## RELEVANT REPRESENTATION OF EBBSFLEET DEVELOPMENT CORPORATION (EDC) IN RESPONSE TO LONDON RESORT DCO APPLICATION – 31 MARCH 2021

- 1.1. London Resort Company Holdings Limited (LRCH) submitted an application for a Development Consent Order (DCO) for the London Resort to PINS on 4 January 2021. The DCO application was accepted for examination on 28 January 2021.

Ref. 6.3.3.2

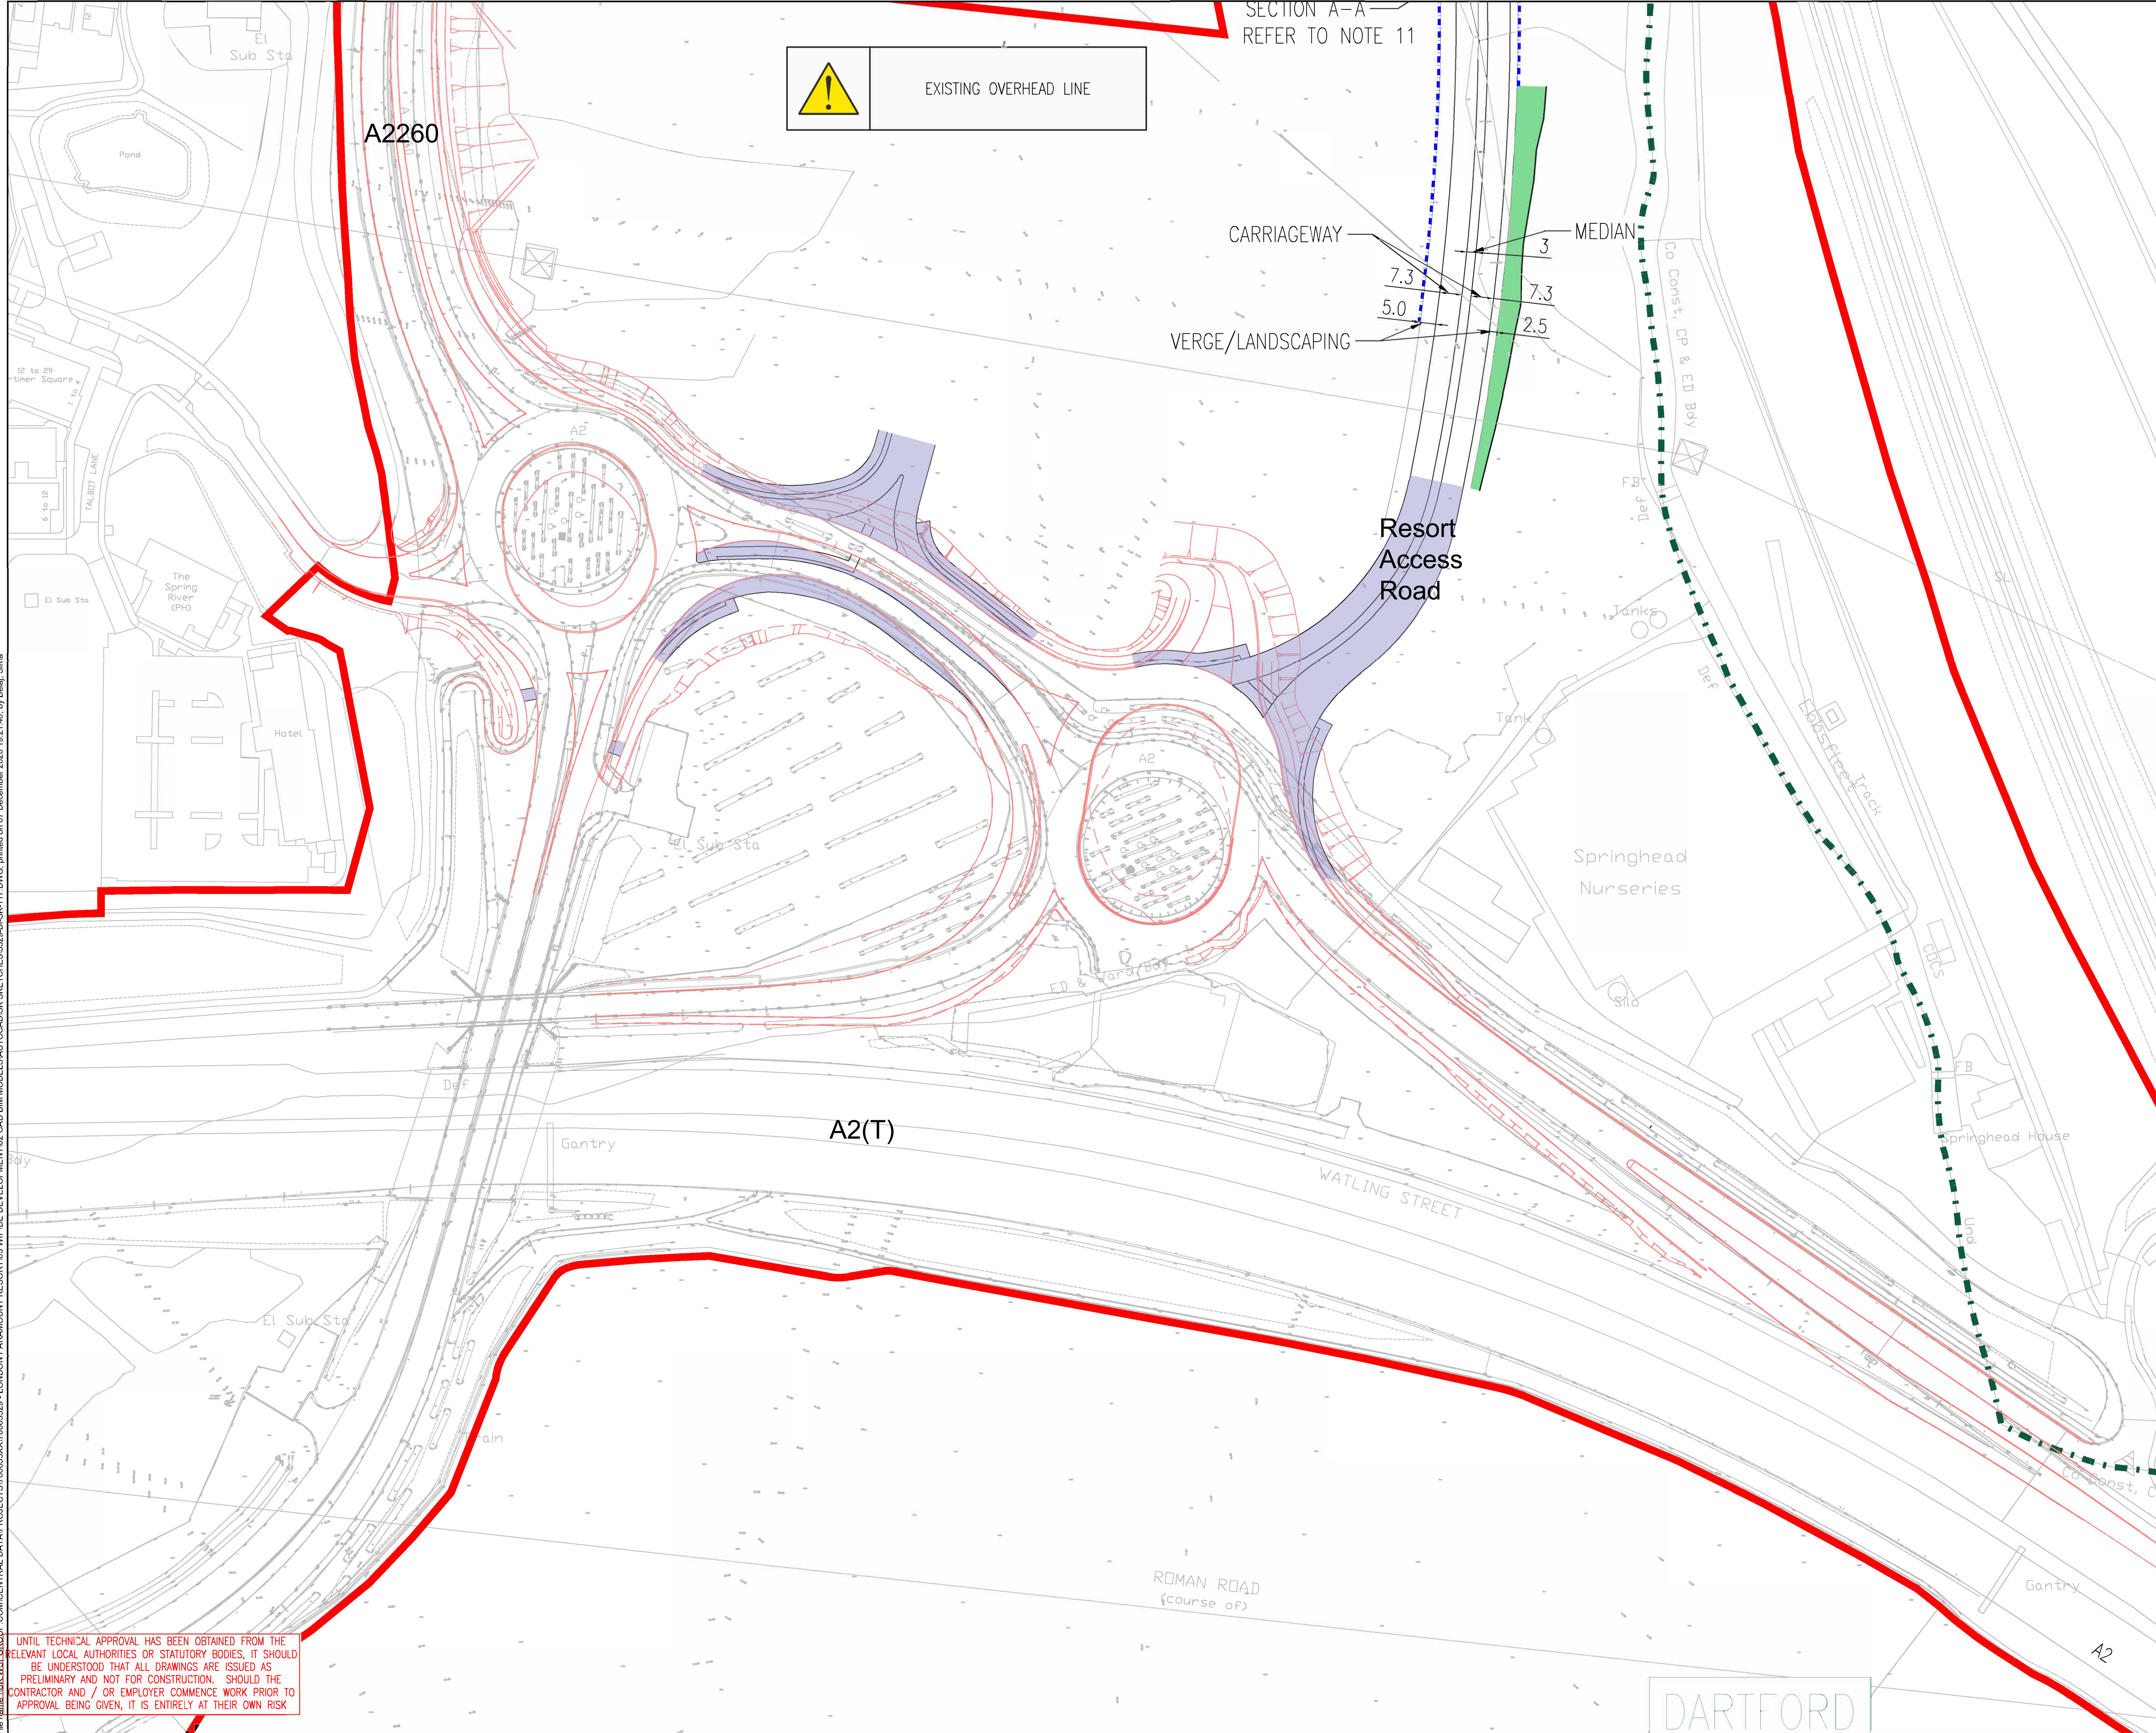
- 4.20. The traffic modelling undertaken for the A2 Ebbsfleet junction and the access to Station Quarter South (SQS) is inconsistent with the proposed design arrangements presented in the scheme drawings included in the Transport Assessment. It is therefore unclear as to the design arrangements that are intended for the junction. The scheme drawings show very little detail in relation to stop lines, signal heads or lane arrangements. It is only from sections of the Transport Assessment that we were able to establish that the access to SQS would be signal controlled. As a consequence, it is not possible to confirm that the design and appraisal of the new junction is appropriate and more specifically what impact it has on EDC's own plans for development.

- 4.21. EDC require clarification on the design arrangements proposed for the A2 junction, including access to SQS, and that evidence is supplied to show the accompanying operational appraisal is consistent with the design proposed. This includes stop lines, signal heads and lane arrangements to be shown on the access drawings as a minimum, as well as details in relation to the proposed phasing and staging arrangements proposed, including those for the access into SQS.

- 4.22. The DCO application states that an allowance for the Ebbsfleet Central scheme has been made in the appraisal for the A2 and SQS junctions. However, there is no data provided in the assessment or associated appraisal documents to explain the total trip forecasts for the scheme nor is there evidence to show this is included within the junction capacity assessments completed. This information is required.
